REQUEST

Current Zoning: O-2 (office)
Proposed Zoning: MUDD(CD) (mixed use development, conditional)

Approximately 1.55 acres located along the southeast side of Colonial Avenue, along the west side of Vail Avenue, and the northeast side of Randolph Road.

Flagship Healthcare Properties, LLC

RZ-300

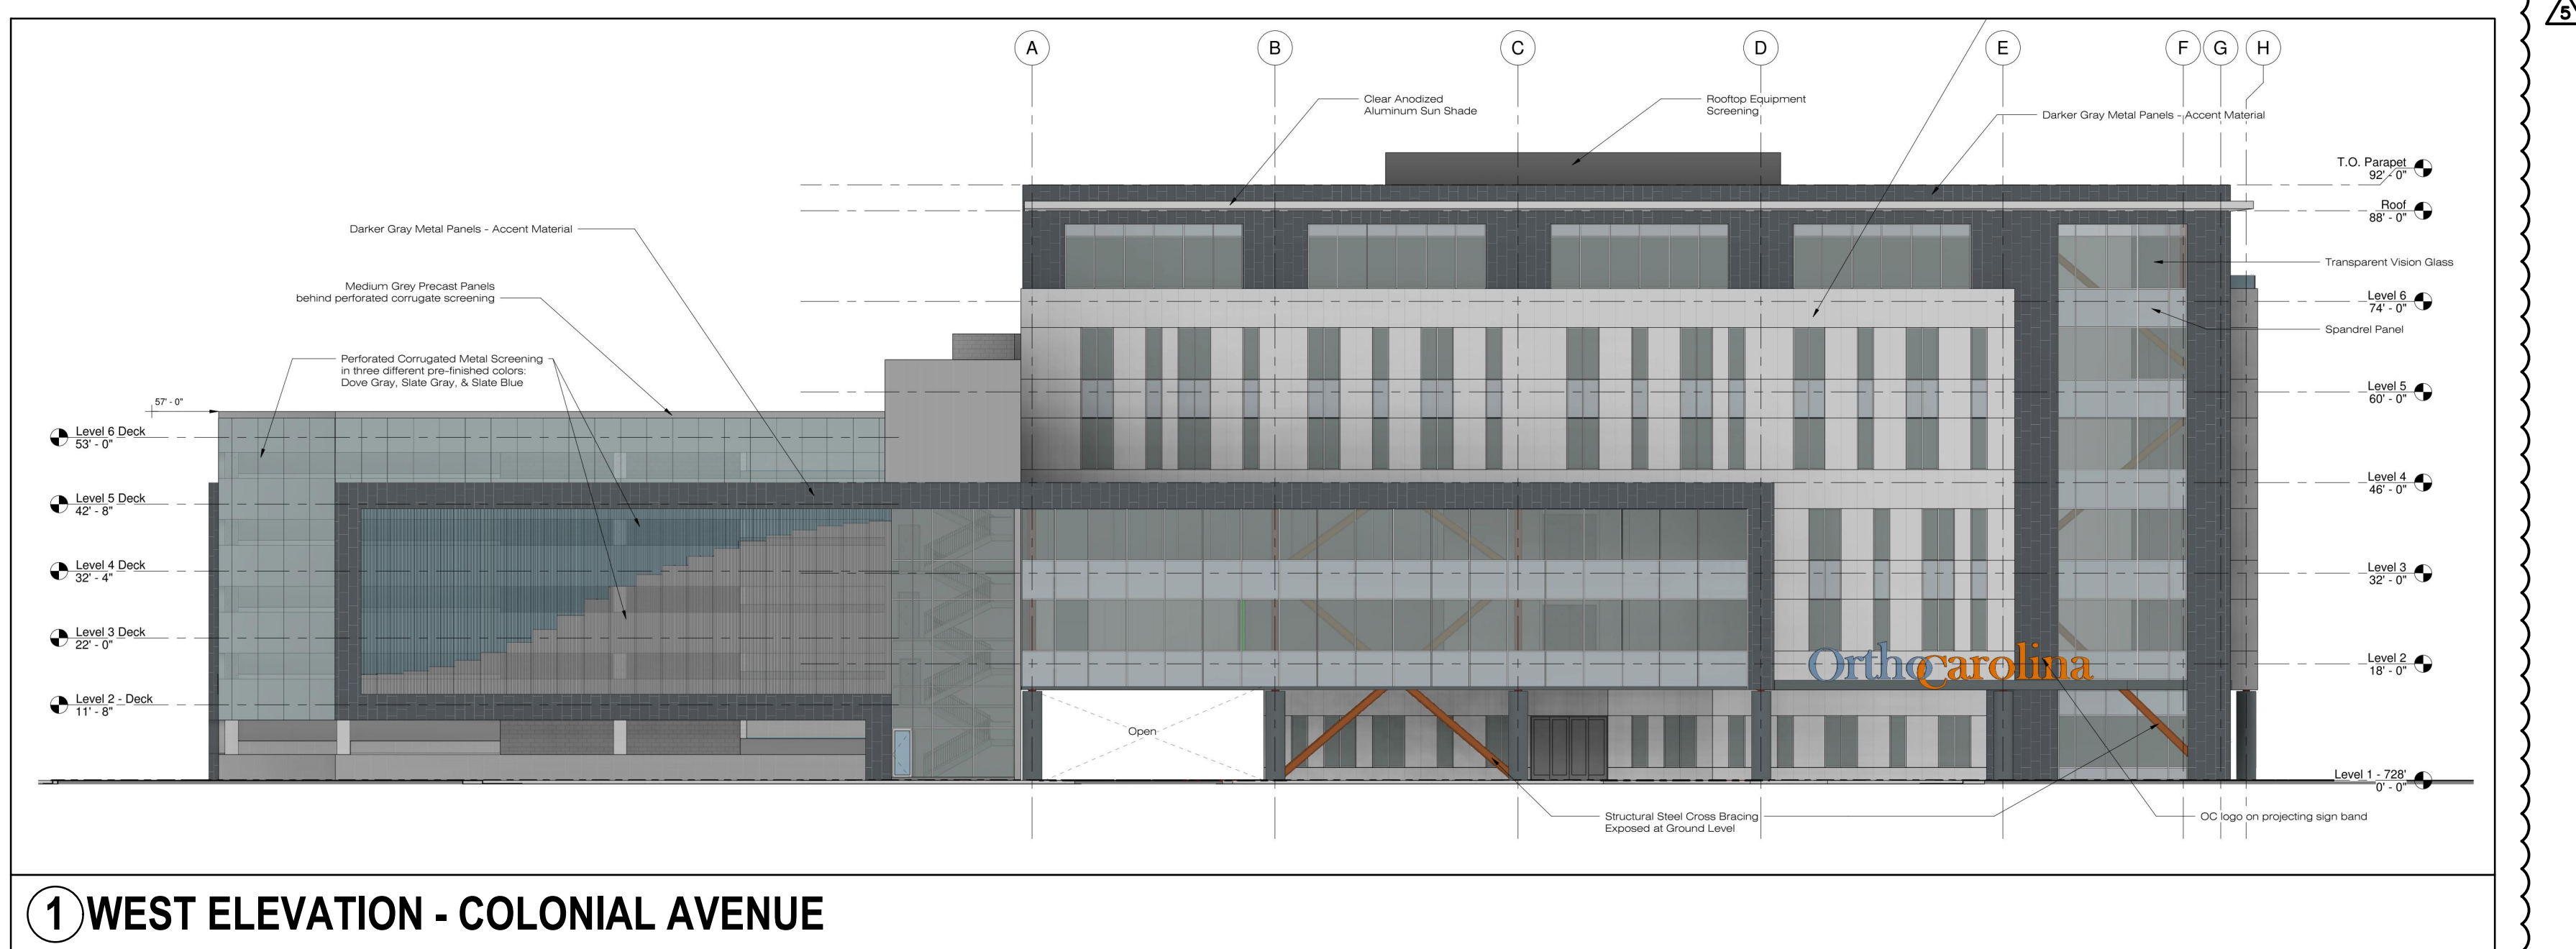
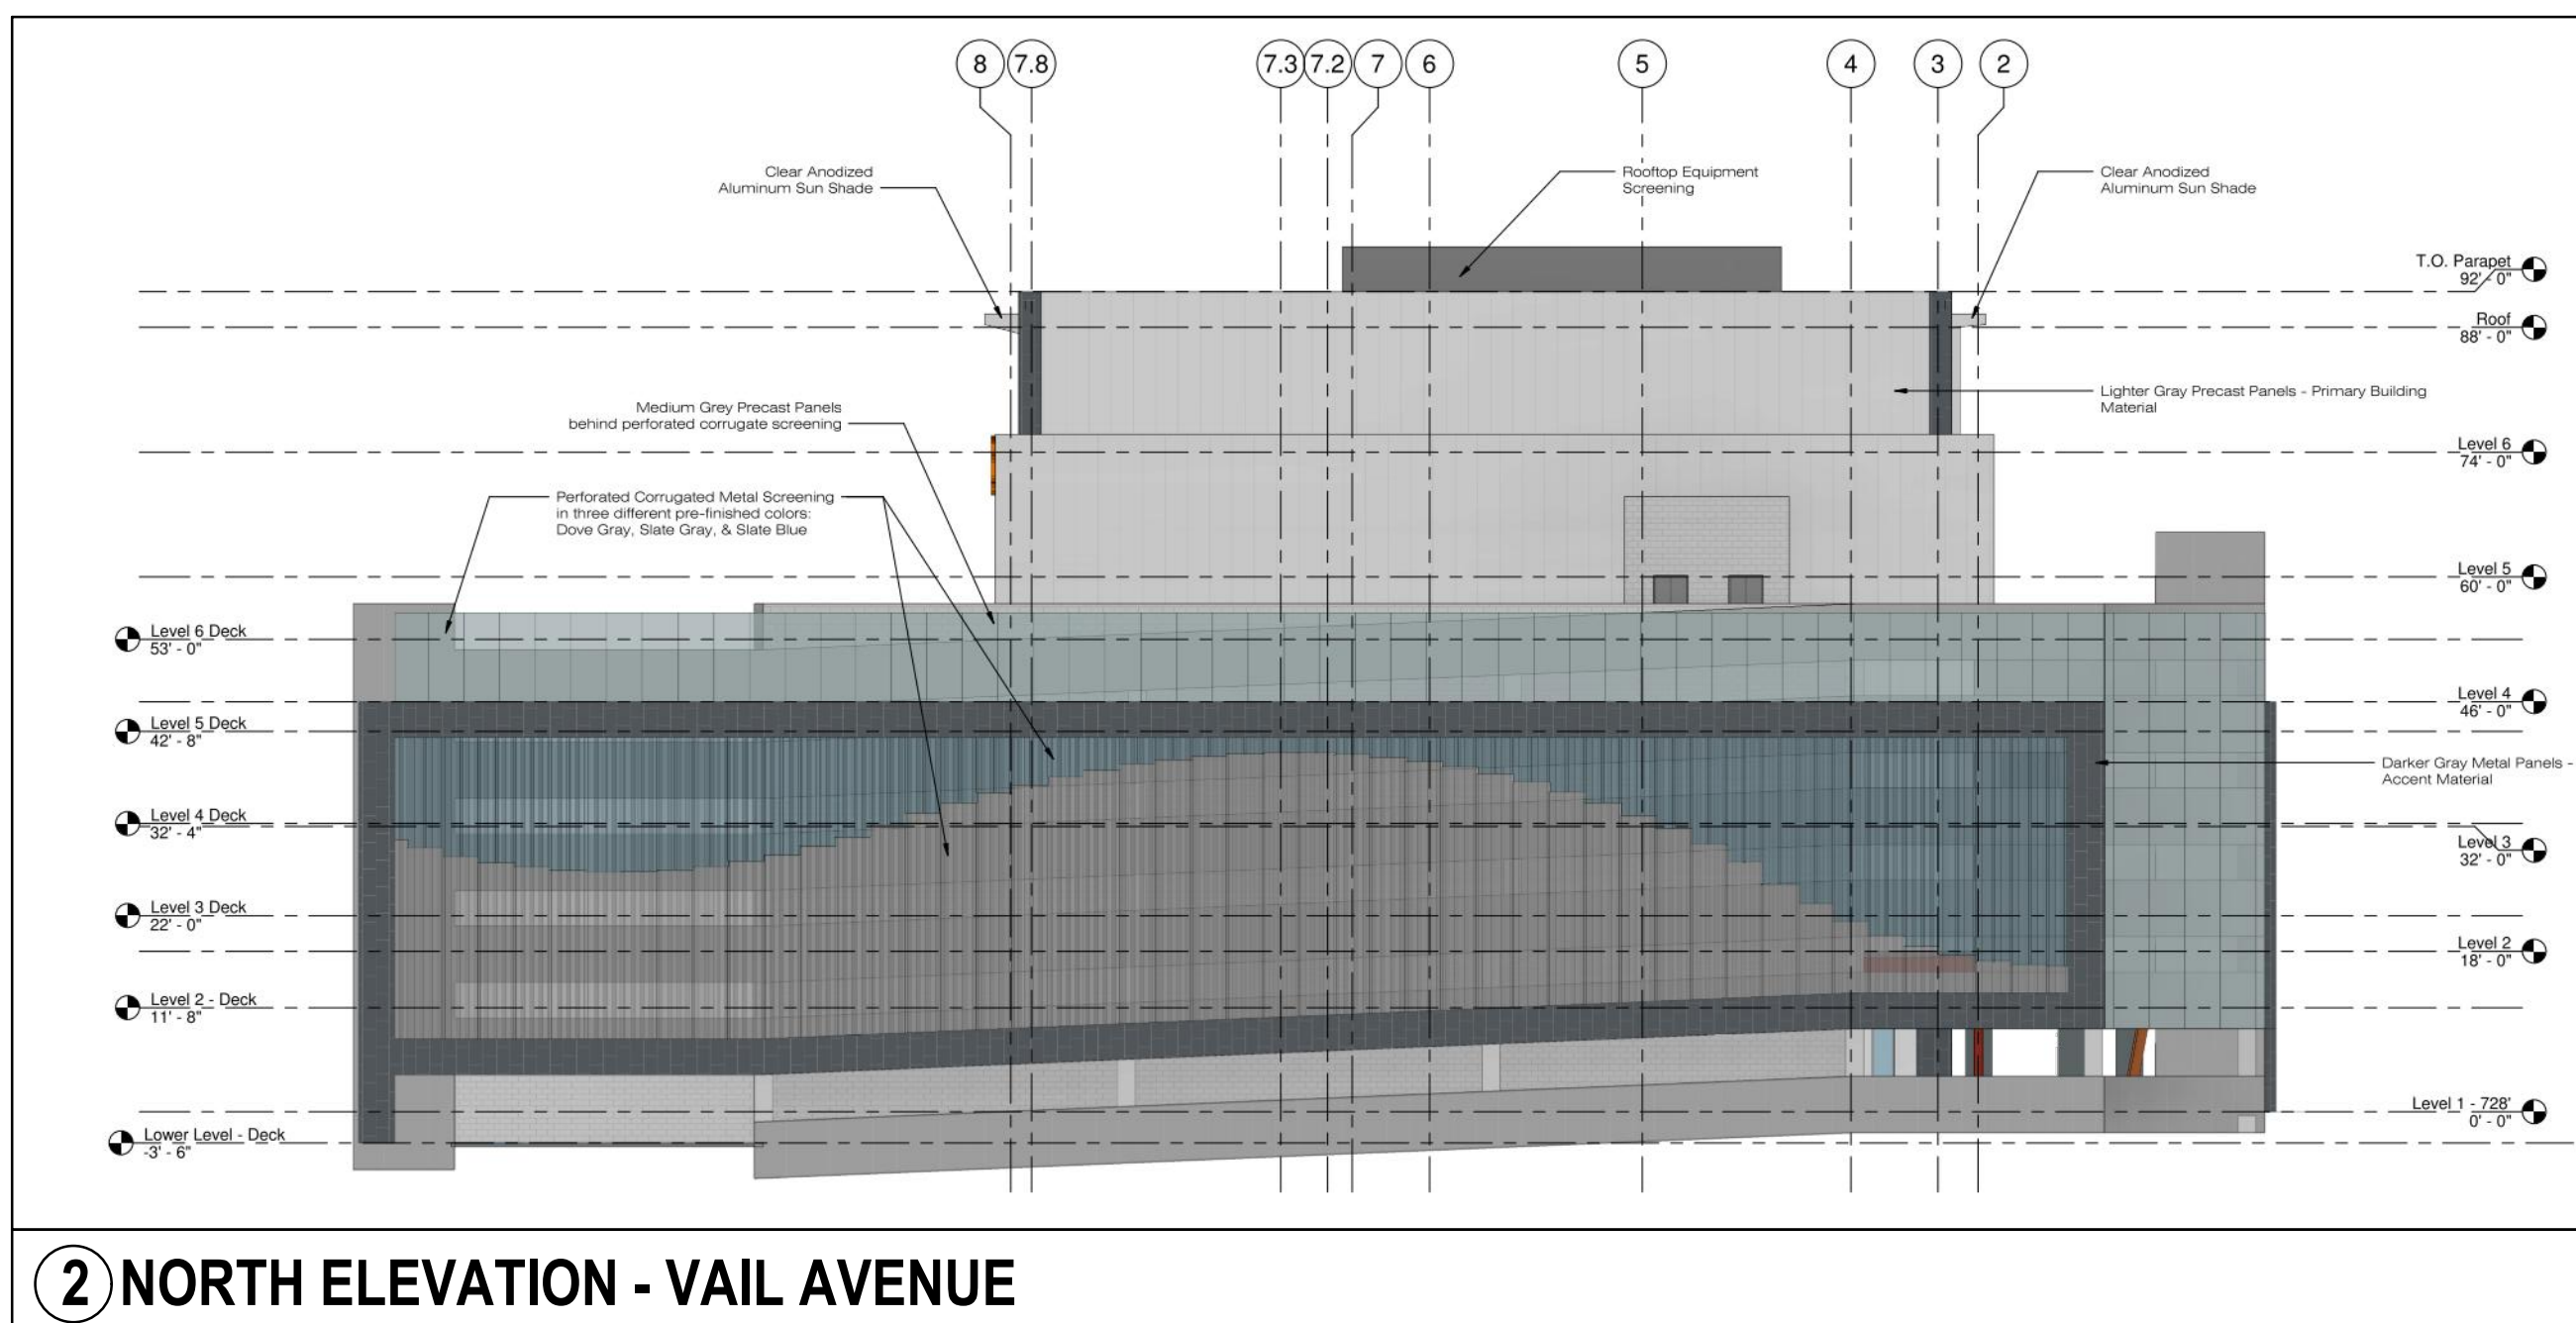
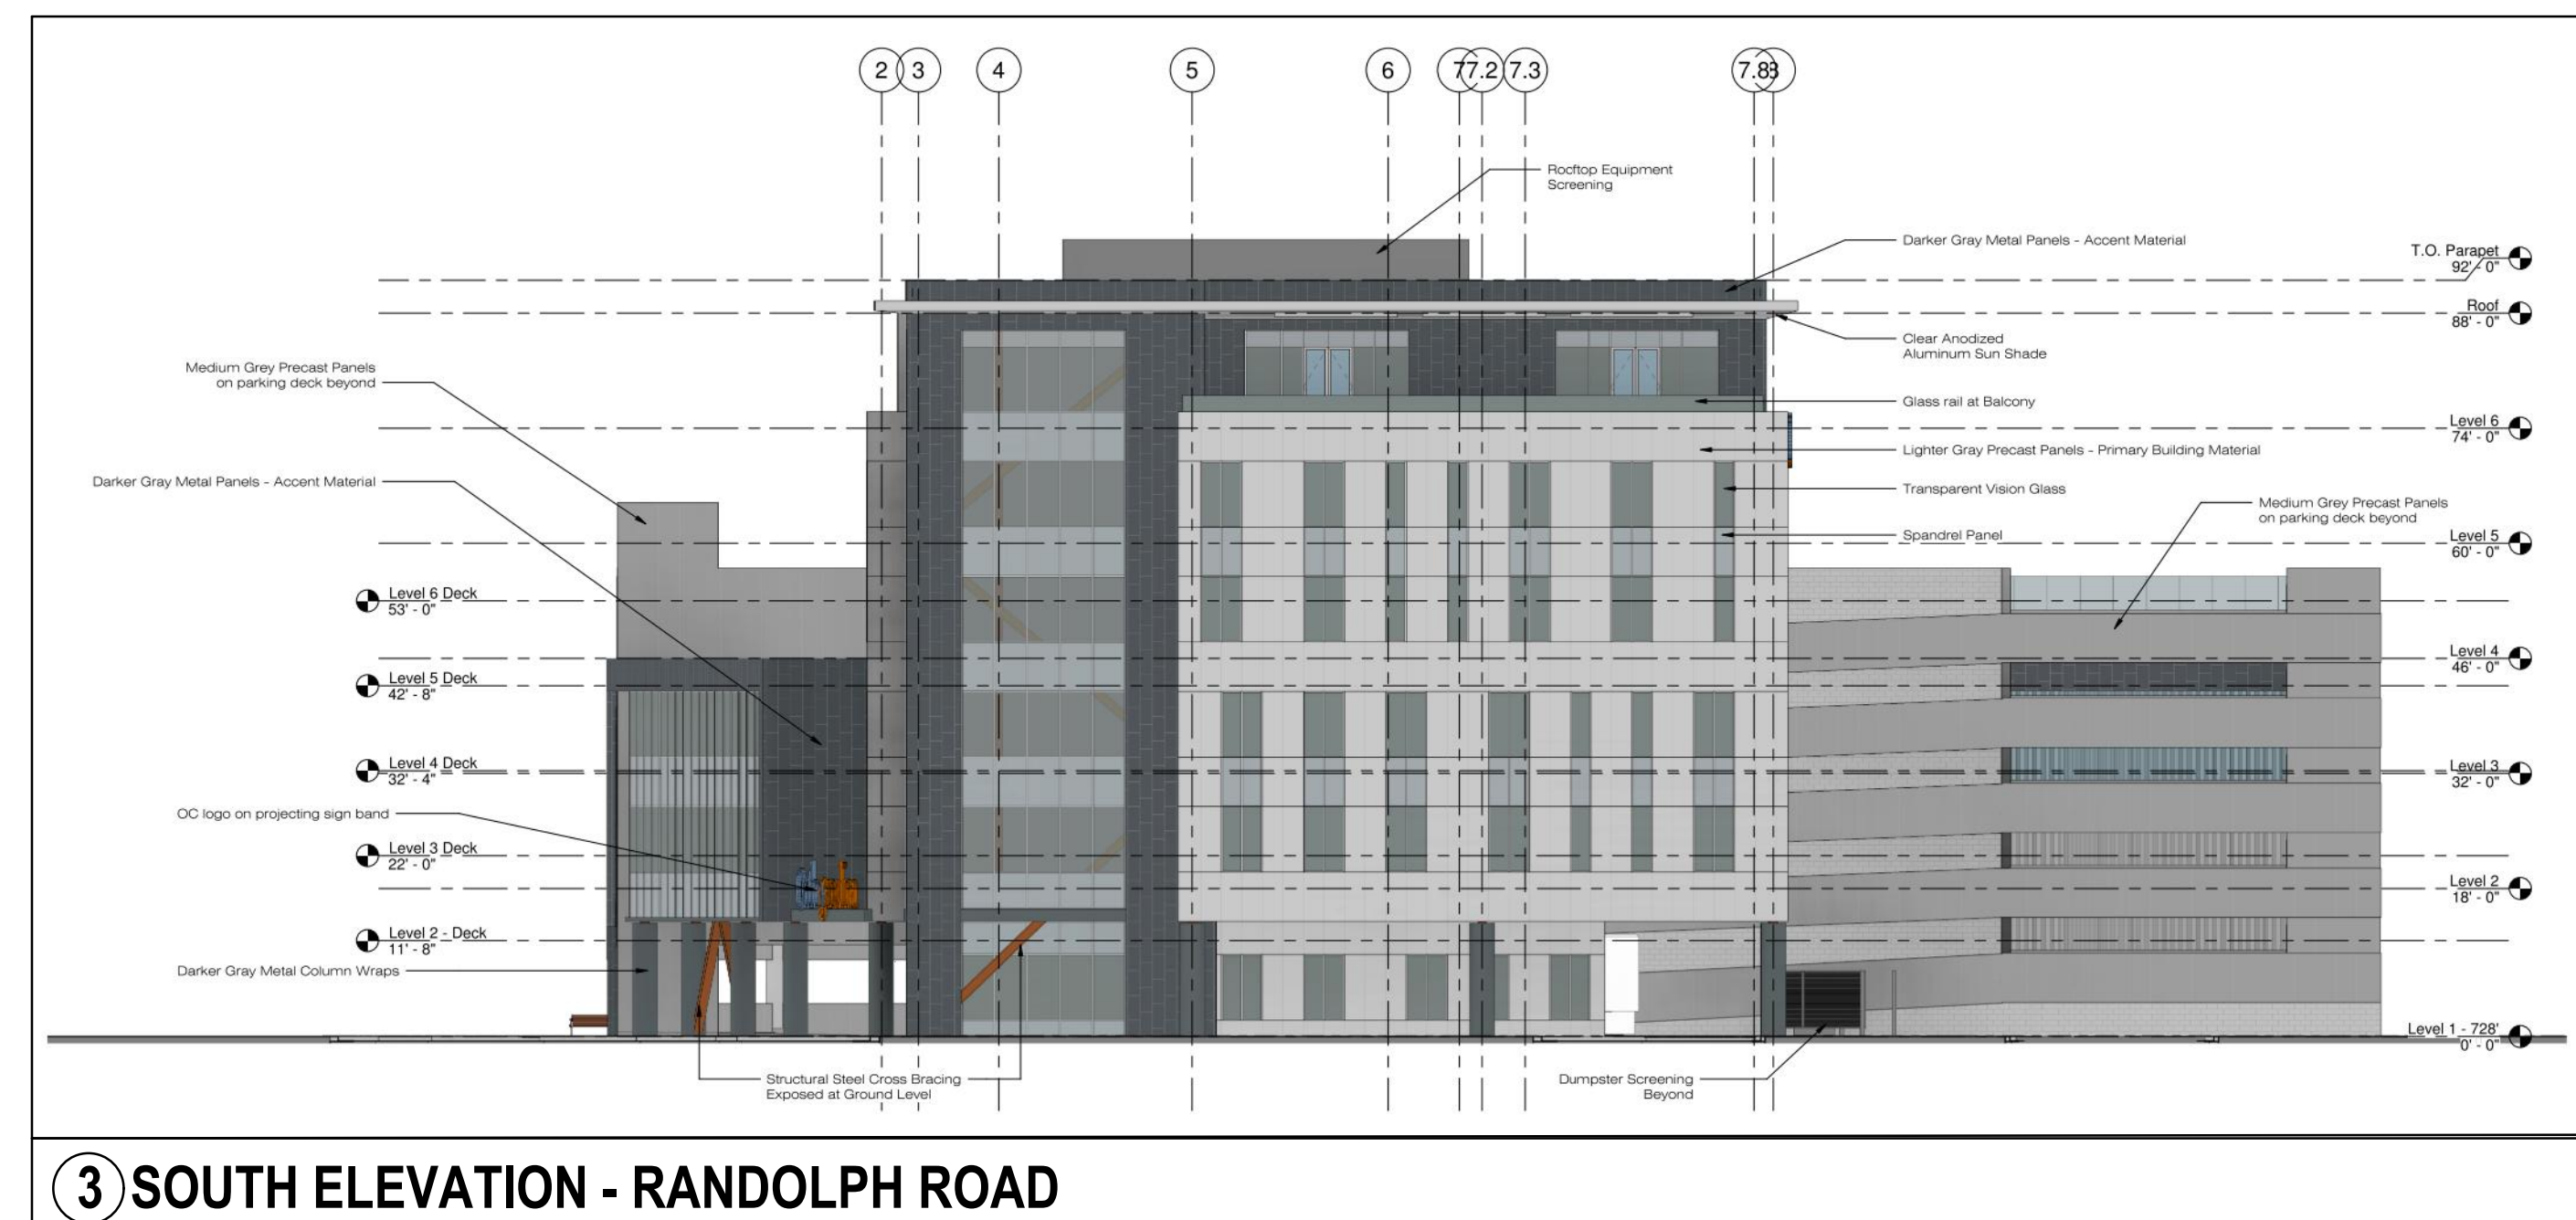
1. Under Site Development Data remove reference to number of stories.
 2. Label 8-foot sidewalk and 8-foot planting strip along Randolph Road and Vail Avenue.
 3. The setbacks labeled on the site plan are different from the 14' noted under Rezoning Summary. The setbacks will need to match what is shown on the site plan.
 4. On the Elevations sheet label east, west elevation (or identified street view). Signage is not part of this review.
-
